## Fire Marshal Division

**Re: Hwy 55  
1600 N. Main St.  
Lillington, NC 27546**

**Application Number FMFW2009-0001**

FIRE SYSTEM OPERATION

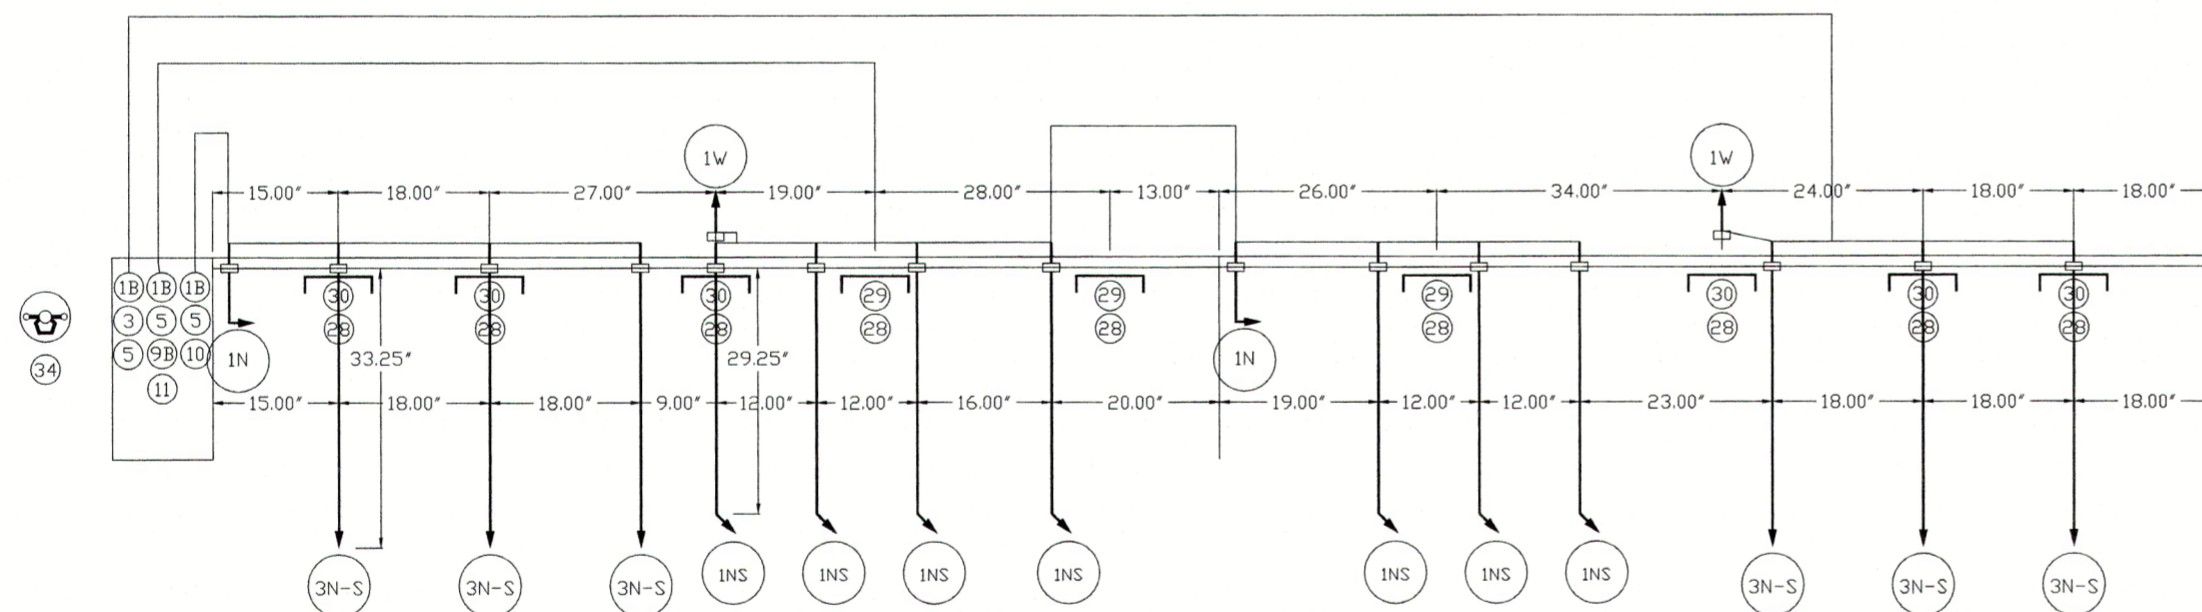
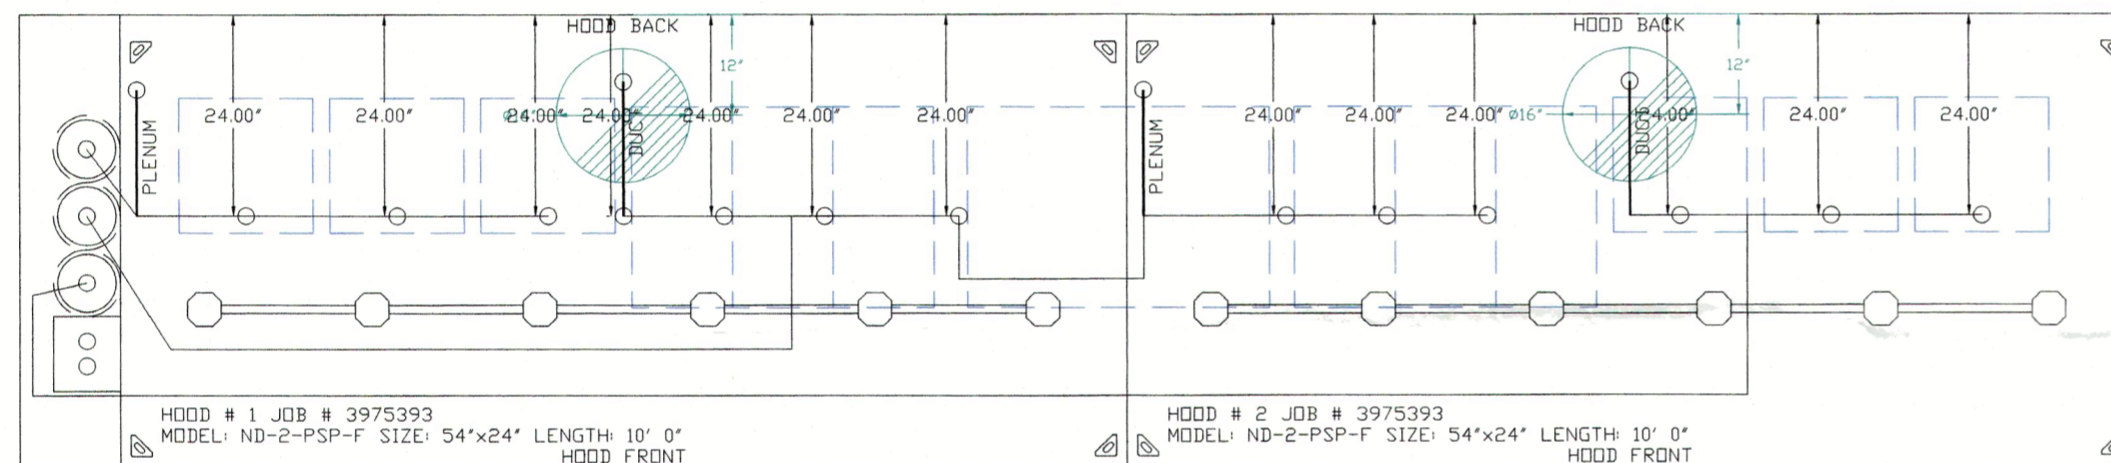
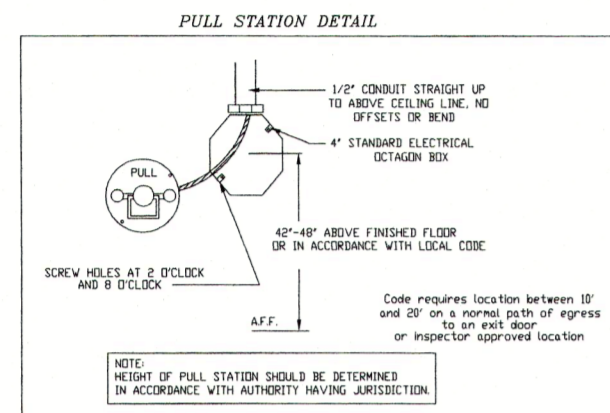
- The actuation of the fire suppression system shall automatically shut down the fuel or electrical power supply to equipment under the hood system. The fuel and electrical supply reset shall be manual.

- **System Interconnection**
  - The actuation of the fire suppression system shall automatically shut down the fuel or electrical power supply to any equipment under the hood system. The fuel and electrical supply reset shall be manual.

PULL STATION DETAIL

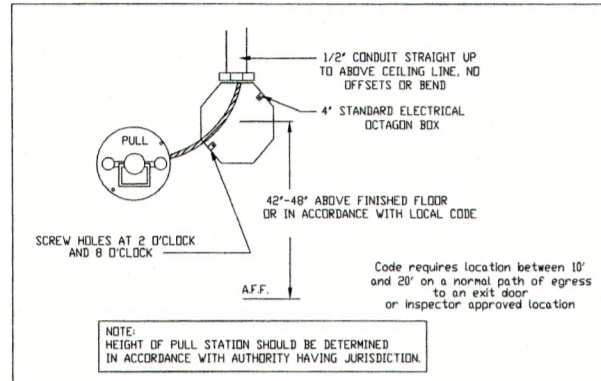
- **Commercial cooking equipment**
  - Portable fire extinguishers shall be provided within a 30-foot (9144 mm) travel distance of commercial-type cooking equipment. Cooking equipment involving vegetable or animal oils and fats shall be protected by a Class K rated portable extinguisher.
- **Acceptance Test**
  - An acceptance test will be conducted by the Fire Marshal's office once system has been installed and pre-tested.
  - Installation shall be per architectural and system submittals and compliant with NFPA-17A.
- **Manual system operation**
  - A manual actuation device shall be located at or near a means of egress from the cooking area, a minimum of 10 feet (3048 mm) and a maximum

of 20 feet (6096 mm) from the kitchen exhaust system.

- The manual actuation device shall be located a minimum of 4.5 feet (1372 mm) and a maximum of 5 feet (1524 mm) above the floor. The manual actuation shall require a maximum force of 40 pounds (178 N) and a maximum movement of 14 inches (356 mm) to actuate the fire suppression system.
